MEADOWBANK EDUCATION AND EMPLOYMENT PRECINCT SCHOOLS PROJECT (SSD-9343) - RESPONSE TO REQUEST FOR ADDITIONAL INFORMAITON

This letter is prepared on behalf of School Infrastructure NSW (SINSW) and responds to the Department of Planning, Industry and Environment's (DPIE) request for additional information from March 2020. The information item and a response are provided below.

Sheet title  
**CAR PARK LEVEL PLAN**

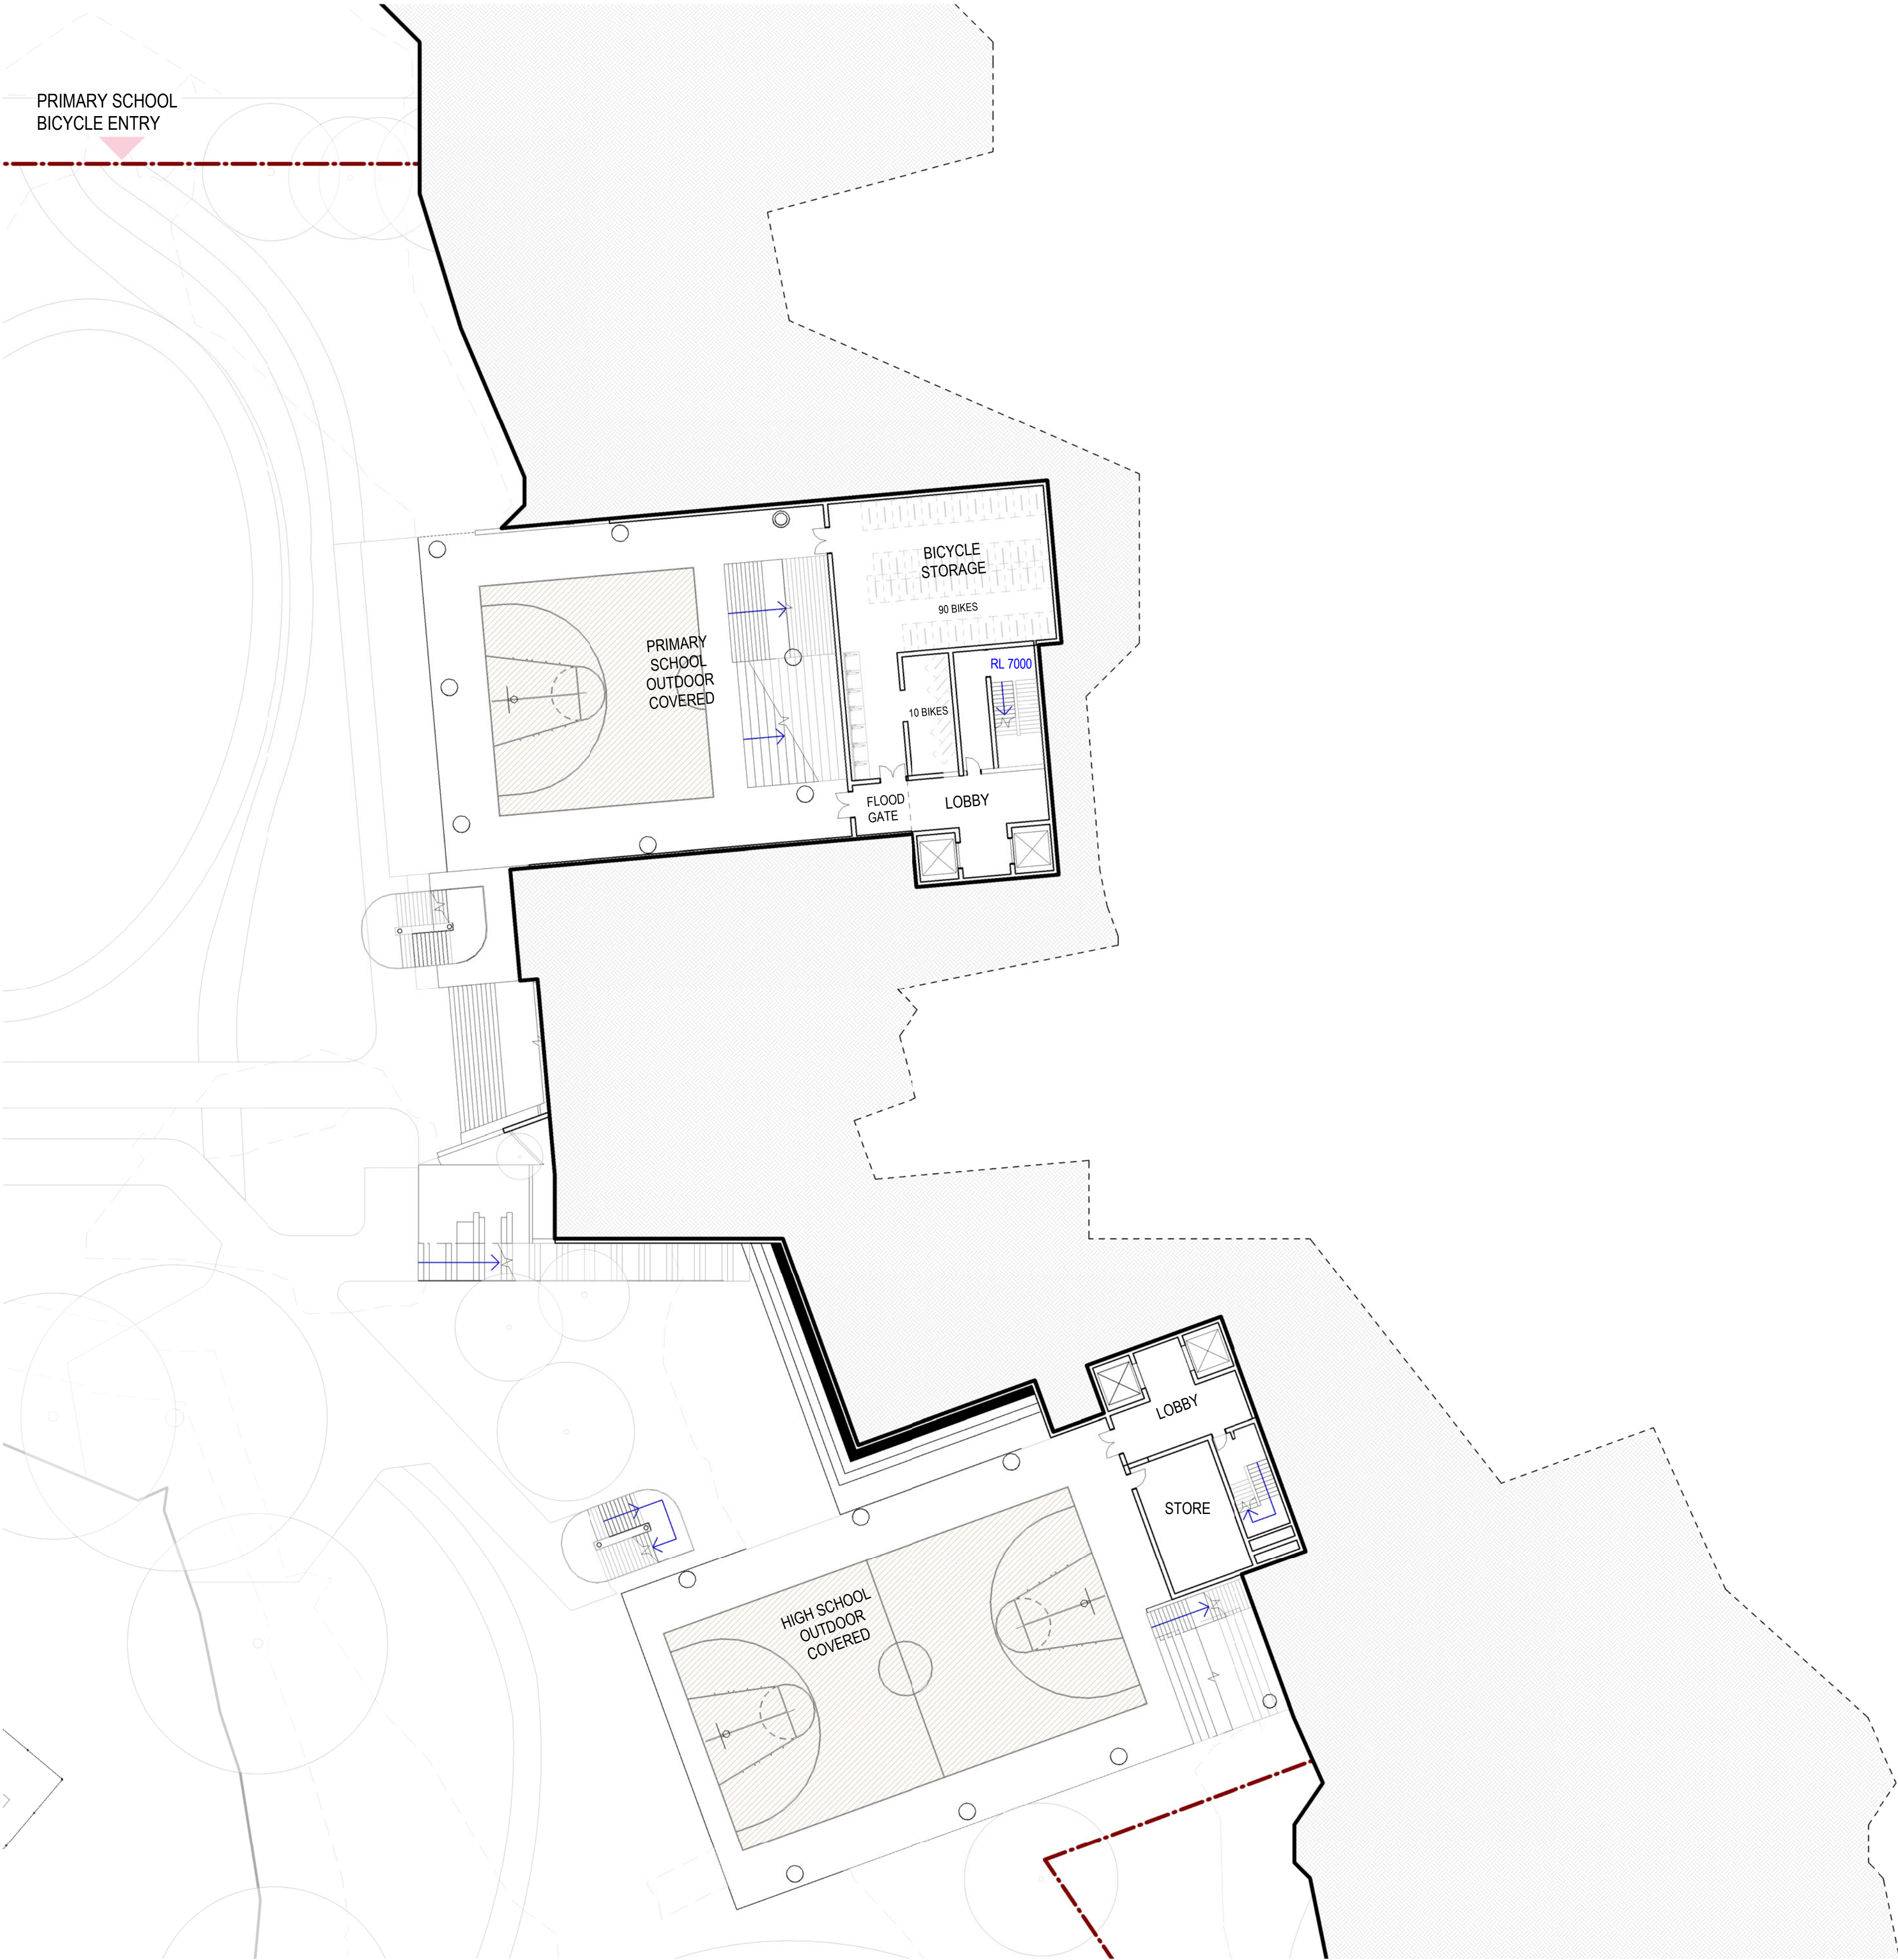
- 1. The flooding documentation indicates the car park entry (8.33m) would be higher than the 1 in 100 year flood event level. However, it would be 7.65m lower than the PMF event level (16.3m). Provide information in relation to the appropriateness of this arrangement and any mitigation measures, including intended emergency management arrangements in the event of a likely PMF event.*

Response: The PMF, by definition, is not likely. The PMF is an extreme event with an annual probability of between 1 in 1,000,000 and 1 in 100,000,000 for the catchment area in Meadowbank. Given the huge backwater effect of the rail embankment, the entire site, including the car park and car park entry, is impacted by the PMF.

Additional flood modelling has shown that the 0.05% Annual Exceedance Probability (AEP) event (2,000-year ARI) results in a flood level of 8.65m AHD. The car park entry has 1.65m freeboard to this level. The car park floor level is 0.85m above the 0.05% AEP flood level. Extrapolating between the flood levels of the 0.05% AEP and the PMF gives an AEP of 0.02% (5,000-year ARI) flood level of 9.50m AHD, equal to the finished floor level of the car park. Should this extreme 5000-year event occur, cars will not be impacted as the water level is not above the FFL. Such a flood event is not likely. This is also considered an extreme event.

The carpark has been designed such that any water entering the basement can flow out of the basement as flood waters recede. Unlike a basement, water will not pond in the car park following and extreme flood event. Other management solutions are not available given the unique situation of the rail embankment holding back flood waters in an extreme event that leads to the PMF being over 8m higher than what is experienced in a 1% AEP event.

Should an extreme flood event occur which exceeds the 1 in 5,000 annual exceedance probability, cars in the car park will be damaged. It is expected that the site would be evacuated (or school cancelled) if extreme weather is forecast, which minimises the risk to site occupants.

In the event the school is open, staff and students can shelter in place, with the classrooms and libraries all located above the extreme PMF level. In such an event, the priority is to ensure the safety of students and staff. This is further achieved by the fact that the main entrance to the school at the eastern most point of Rhodes Street being unaffected by the extreme PMF allowing suitable access should an evacuation need to occur. This is an appropriate arrangement for extreme circumstances.
